REPORT UPDATE

Application No: AL/67/25/PL

REF NO: AL/67/25/PL

LOCATION: Nyton Rest
Nyton Farm Shop
Nyton Road
Aldingbourne
PO20 3TU

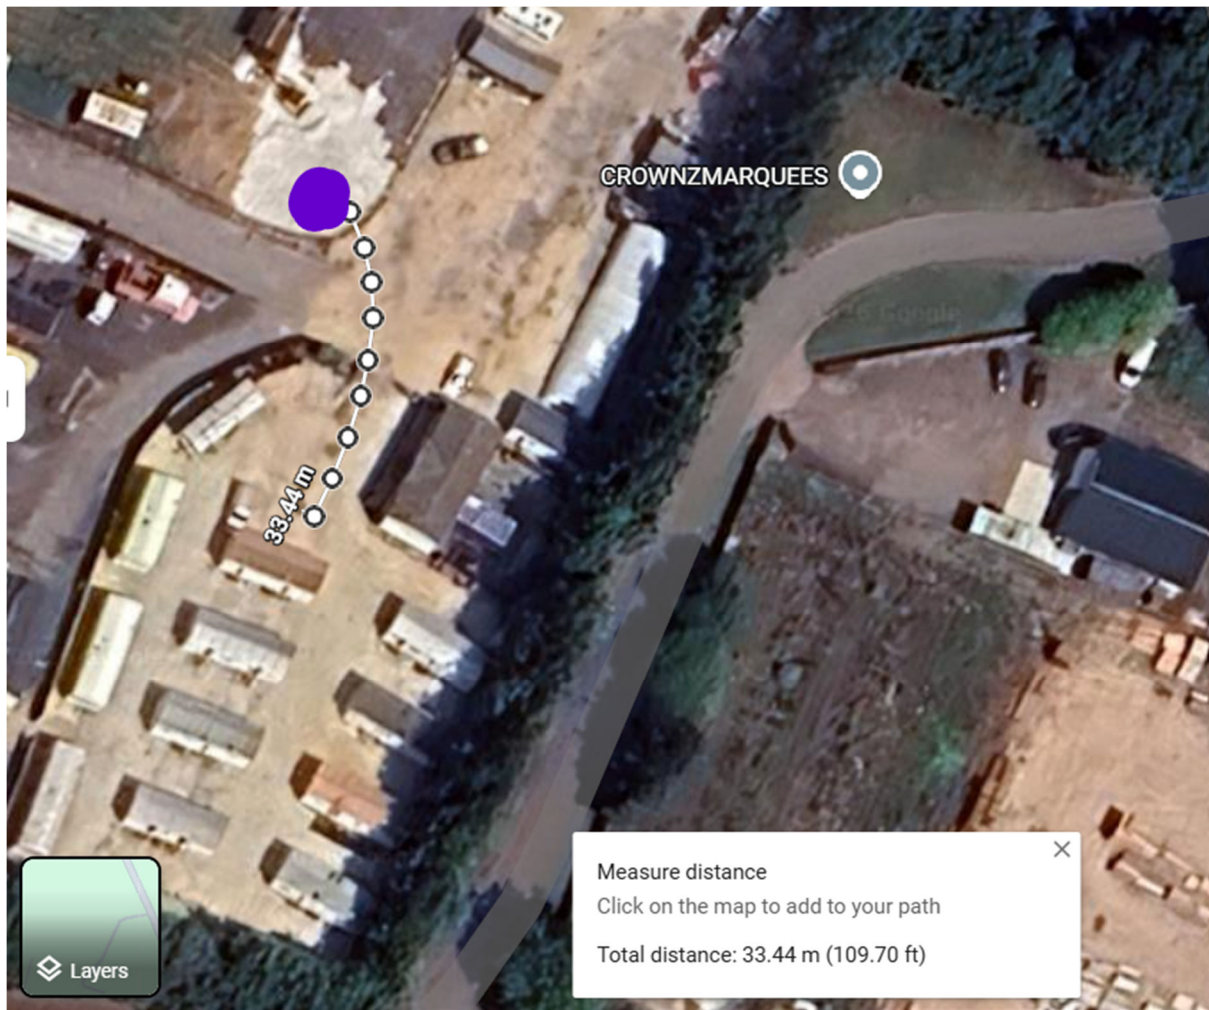
- In addition, the applicant has provided a plan to demonstrate that a fire tender can park in a position that allows the fire fighters to connect the tender to the water tank and also to ensure that all caravans are within a 45m hose lay distance of the tender.

WSCC FIRE AND RESCUE - states that the nearest fire hydrant for the supply of water for firefighting is 455m away, 280m further than the 175m distance required for domestic premises, and 365m further than the distance required for commercial premises. Requests consideration of an alternative water supply for firefighting. Also request evidence that a fire vehicle can access the site.
